From: [REDACTED]
To: [SizewellC](#)
Subject: Fwd: Response to BEIS request Ref: EN010012 18th March
Date: 21 March 2022 06:51:08
Attachments: [Response to BEIS Enquiry Ref EN010012 18th March 2022.pdf](#)
[SzC Main nuclear platform flood resilience in the next century.pdf](#)

RE: Response to your ref: EN010012 18th March 2022

BEIS's enquiry, Ref: EN010012, 18th March 2022, contains a reference to 'Coastal Considerations' and requests the Environment Agency to confirm that it is satisfied by TR544 REP10-124, as follows:

Sizewell C Main nuclear platform flood resilience in the next century.

Figure 14 The loss of sediment volume from the BfE storm in 2099 with receded lateral shorelines (left) and the remaining sediment volume of the SCDF after the BfE storm (right).

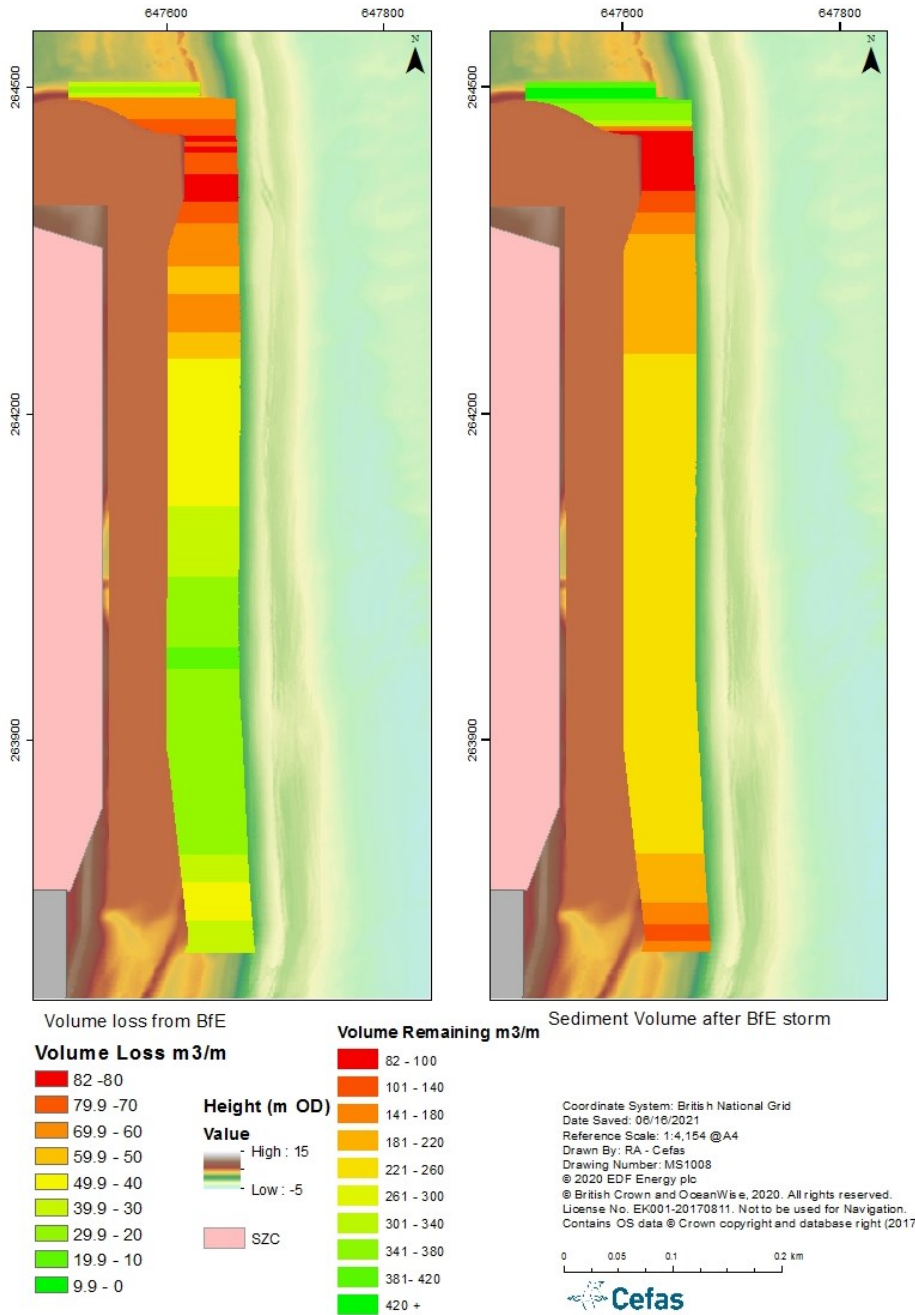
The 'severely receded shoreline' claimed by TR544 is shown following (Page 49 TR544 REP10-124) and reproduced below:

In my view, this shoreline cannot be regarded as 'severely receded' and hence cannot be regarded as 'conservative modelling'.
